Reference No:	2025/62/90768/E
Site Address:	Land Adj, 2, Hopton Hall Lane, Upper Hopton, Mirfield, WF14 8EP
Description:	Erection of detached dwelling and associated external works
Recommending Officer:	Edward Cheseldine

DECISION - REFUSED

Officer Report

2025/90768 - Land Adj, 2, Hopton Hall Lane, Upper Hopton, Mirfield, WF14 8EP

EAST ELEVATION
1:100

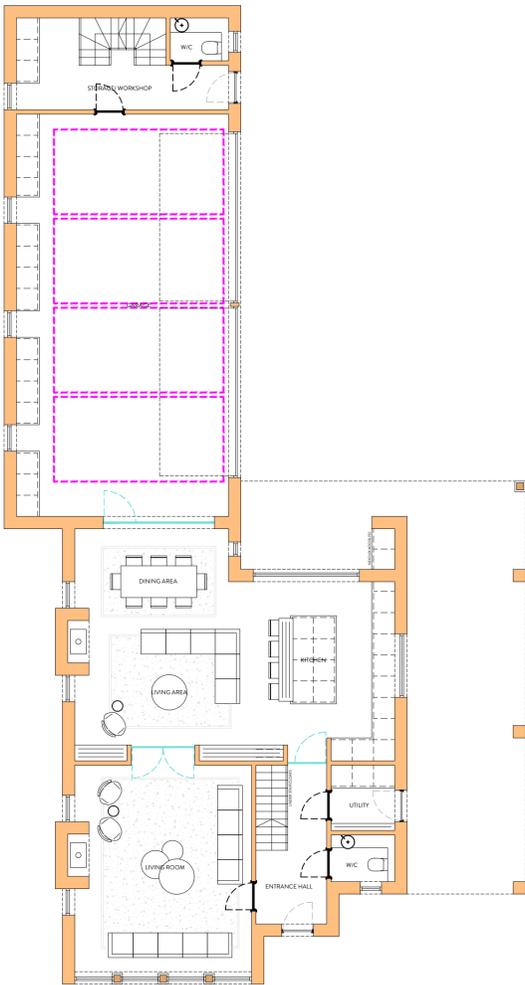
The proposed dwelling will accommodate a significant proportion of the housing plot due to its scale, concerns in this regard were previously raised, and this development introduces only minor amendments in terms of scale. There is a considerable vertical massing on the southern boundary as the pitched roof extensions along it to a height of 7.10m at a length of 27.70m.

As a consequence of the scale and design, the dwelling appears disproportionate to the size of the plot. It contains a large rear projection that appears disconnected to the front section. Vertical massing is located along the length of the site in the form of a two-storey section that reduces to a 1.5 storey section. The built form therefore dominates the plot given the remaining space around the property. It is acknowledged that the some of the vertical massing of the dwelling has been reduced since the previous application, due to the change to a hipped section of roofing, however the overall footprint and scale has only marginally been changed, leading to a cramped form of development.

The property features a hipped-cross-pitched roof. The hipped roof form at the front of the building, removes the block appearance of the front of the dwelling from the previous application. The build-up of vertical massing along the southern boarder has been minorly reduced, however remains dominant. The design of which does not respect the existing spatial pattern or the topography of the site. Considering how the rooflines join, the design is incongruent.

PROPOSED SECTION B-B
1:200

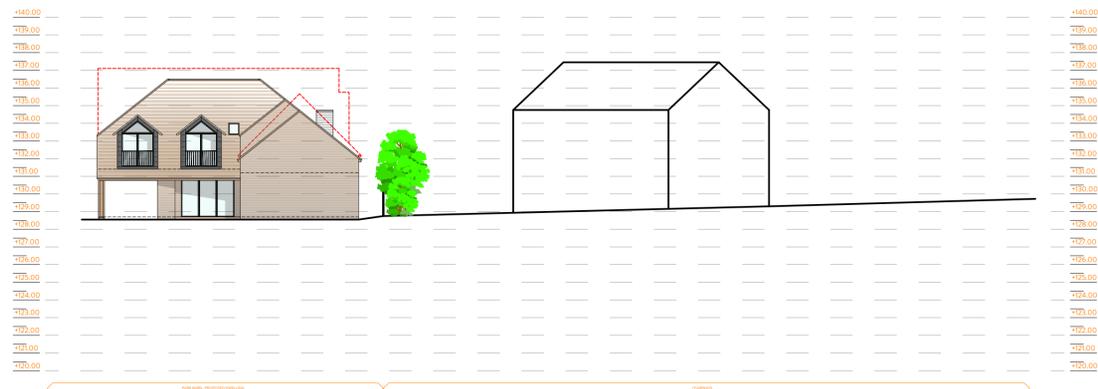
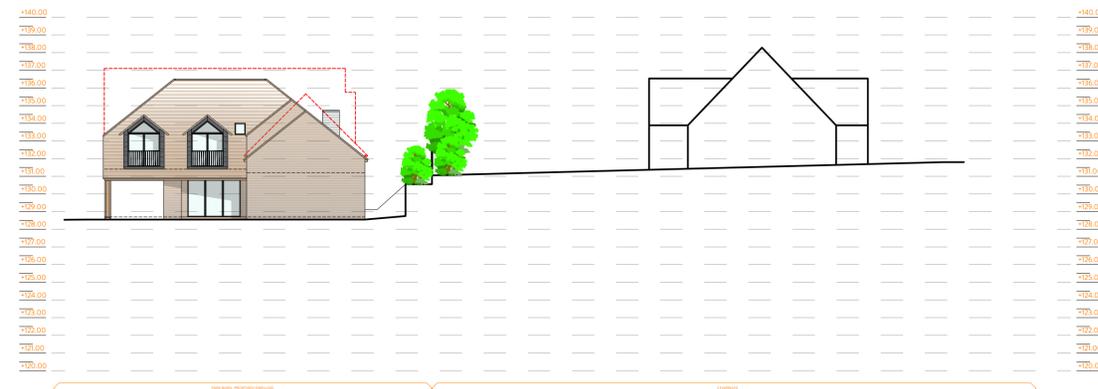
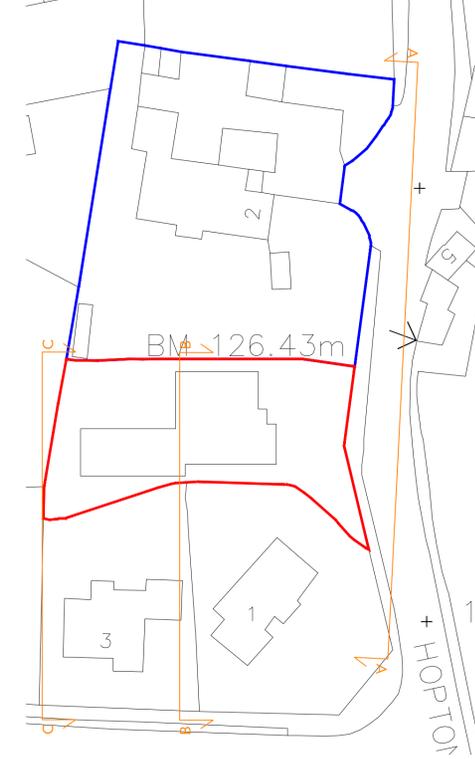
Windows at 3 Fairways light a kitchen/diner and a bedroom. At this particular point in the ridgeline height is 12.45m. The ridgeline will be set away from habitable windows by 19.45m. Therefore, there will not be a loss of outlook, or a loss of light.

As the roofline is set away from the boundary, there will not be an overbearing impact when the garden space is in use given the height and distance between the ridgelines.
